2025/0028

13 Monk Terrace, Monk Bretton, Barnsley, S71 5RR

Demolition of existing conservatory and erection of single storey extension to side of dwelling.

Proposed Floor Plan - 1:100

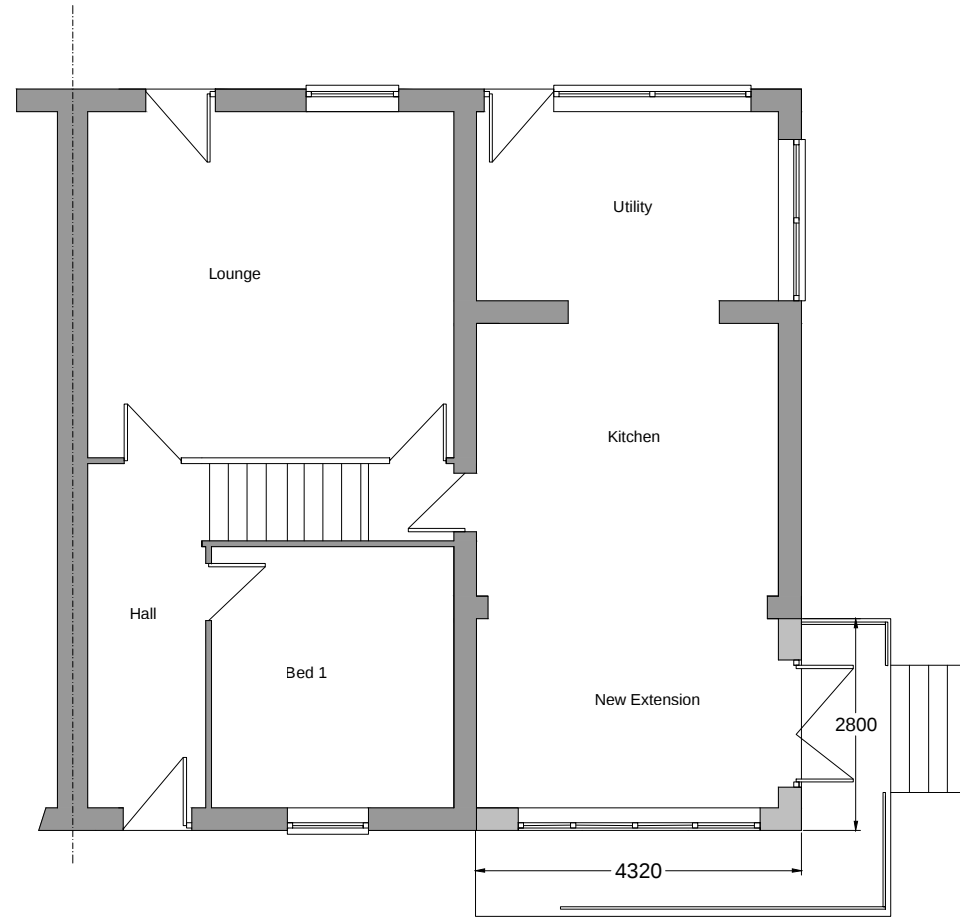
The proposed side extension would replace the floor space of the existing conservatory. A southwards projection of approximately 4.3 meters is proposed with a projection forward of the existing side extension of approximately 2.8 metres. An approximate eaves height of 2.1 metre sis proposed with a proposed ridge height of approximately 3.7 metres. A lean to pitched roof is detailed featuring two roof lanterns facing westwards. Windows are detailed to the front elevation of the extension along with patio doors providing access to the south elevation. Steps are detailed externally to the south elevation of the proposal providing access to the patio doors and a veranda at ground floor level. The proposal would be constructed from chalk coloured render along with charcoal synthetic tiles.

The proposed extension would be erected to the south of an end terrace. No further dwelling are located on the street and the south of the site is screened by large trees and bushes. The front of the site is also substantially screened by a wall and an existing detached garage. Given the proposal is a single storey extension as is a similar size to the existing conservatory, the proposal will have little no impact to the residential amenity of neighbours. The minor veranda created to the south of the site poses no issues and simply provides access to the patio doors on the south elevation. As such, this weights substantially in favour of the proposal.

Proposed Front Elevation - 1:100

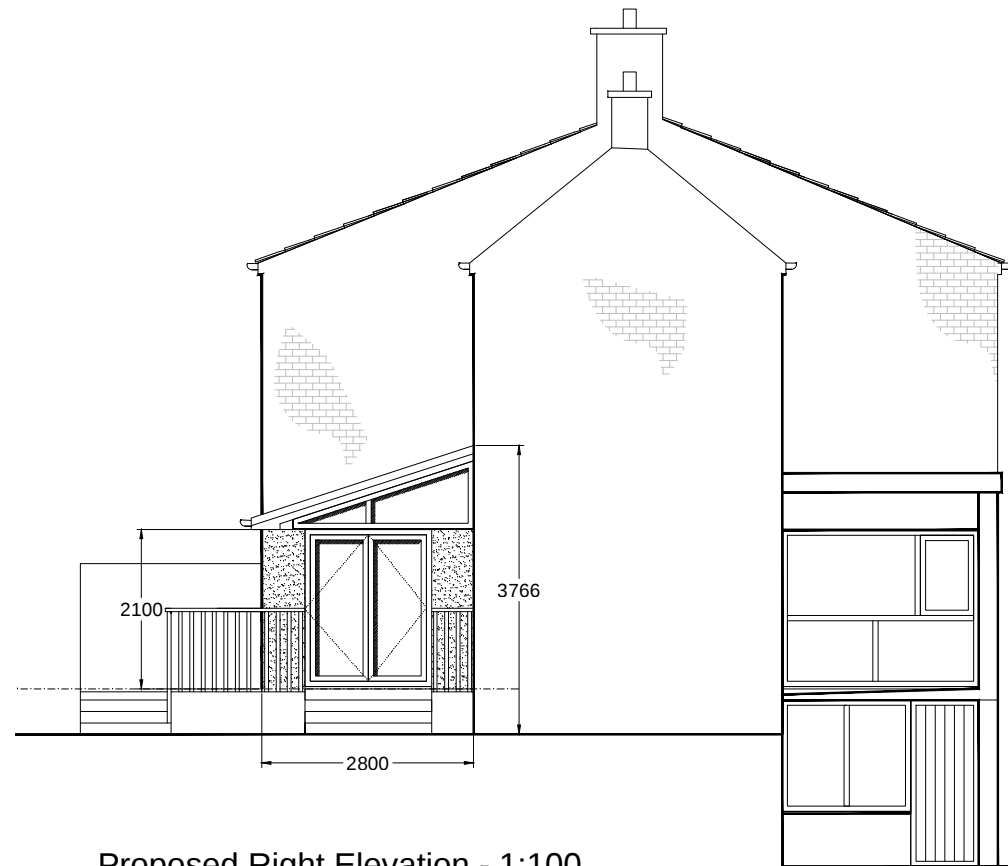
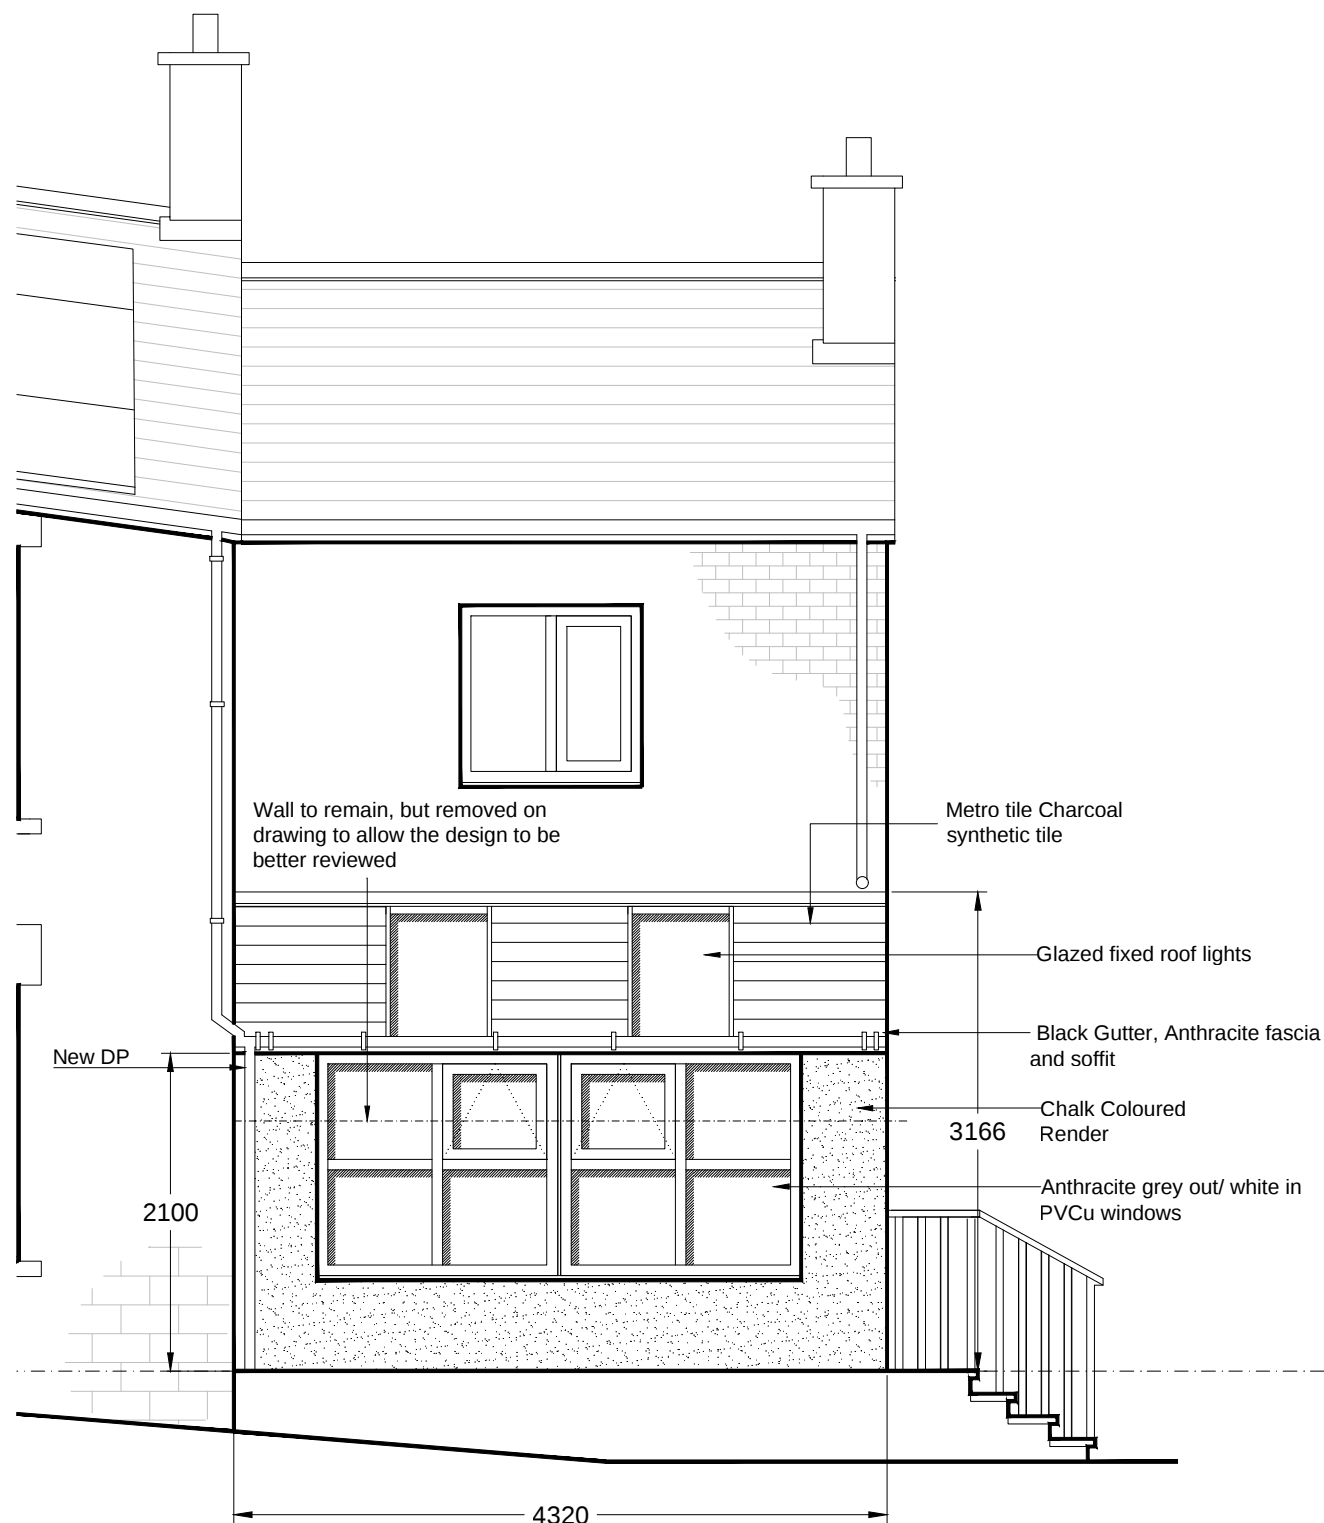
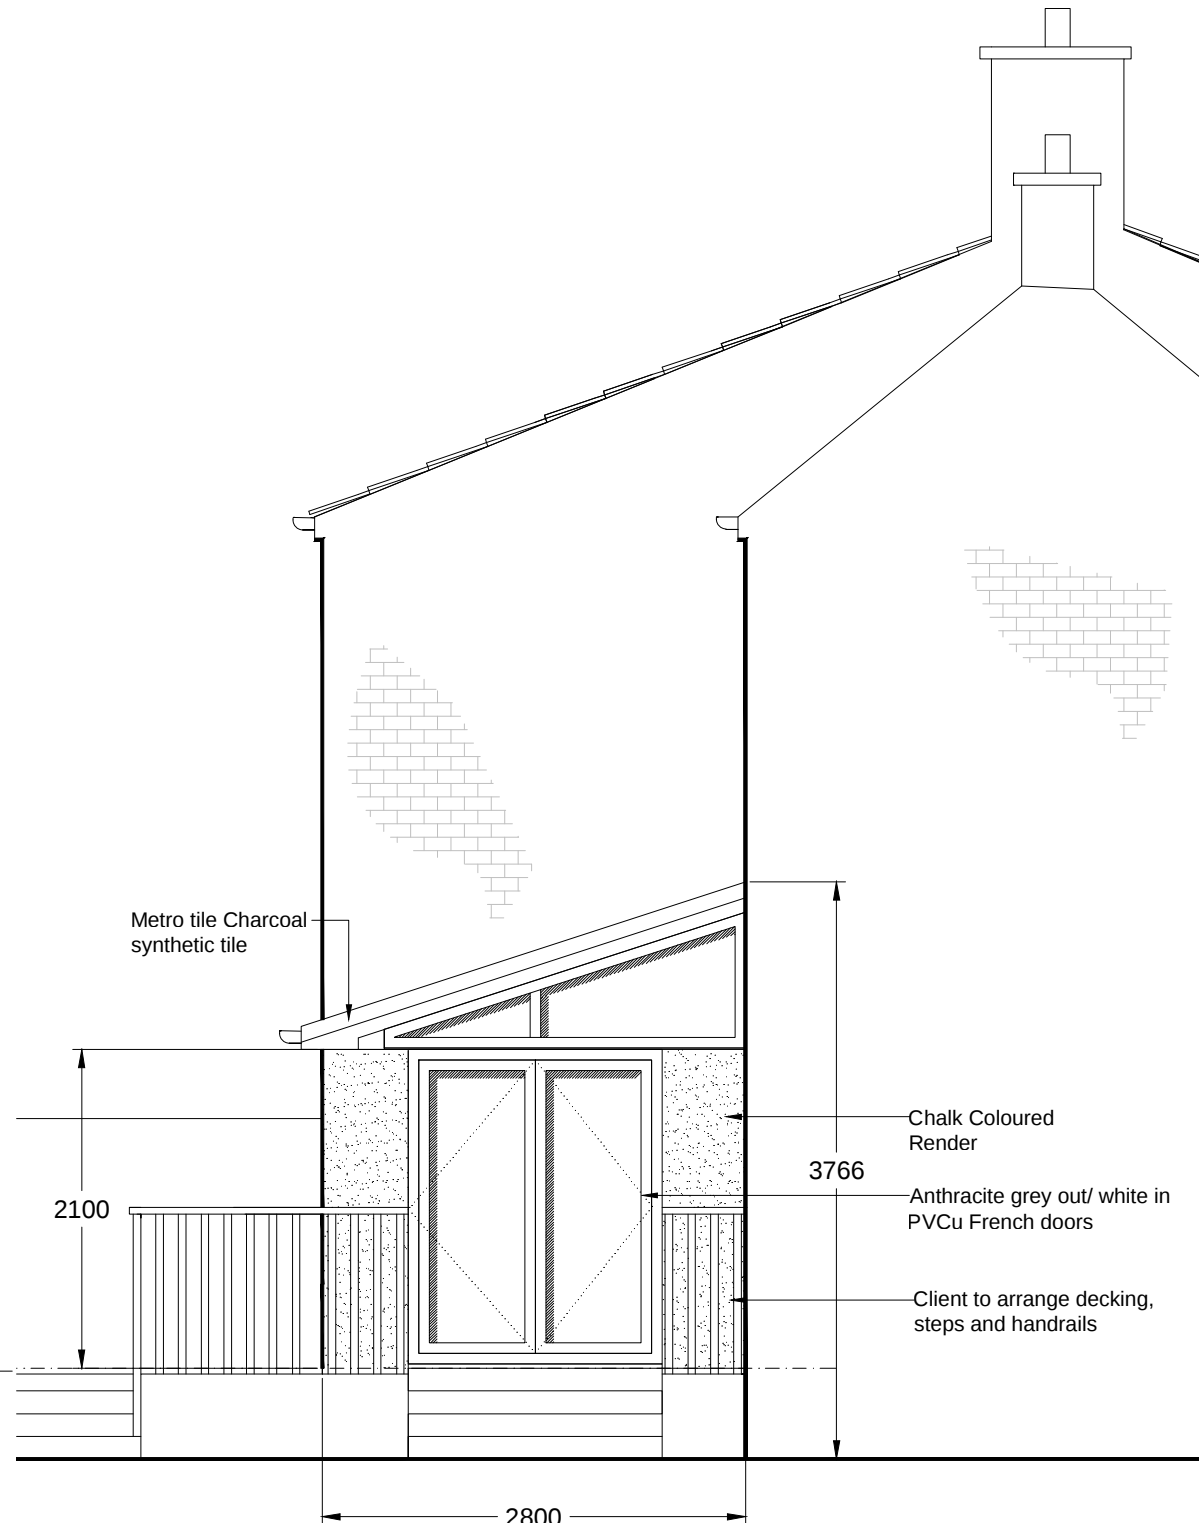
The proposal would replace the existing conservatory and would essentially change the front elevation of the property. The proposal would provide an improved visual appearance to the dwelling and the street scene. A lean-to roof is detailed at a greater pitch to the existing conservatory roof and is more in keeping with the roof of the dwelling. Furthermore, tiles have been proposed which further matches the materials of the dwelling. Although substantial glazing is detailed to the front elevation and in the form of roof lanterns, again this is a reduction on the existing glazing of the conservatory and so is welcomed. The use of chalk render is acknowledged. Although little render is evident in the area and is not present within the street scene, the use of render would be considered more in keeping with the stone on the street scene than the existing conservatory glazing. Additionally, the screening to the front of the dwelling assists in reducing the impact of the extension.

In considering the above assessment, the proposed development is acceptable regarding residential and visual amenity and highway safety. Although some concerns are present with regards to the visual amenity of the proposal in terms of the materials used; the proposal is considered to be an improvement on the existing conservatory for which the proposal seeks to replace. On balance, this application is therefore recommended for approval.
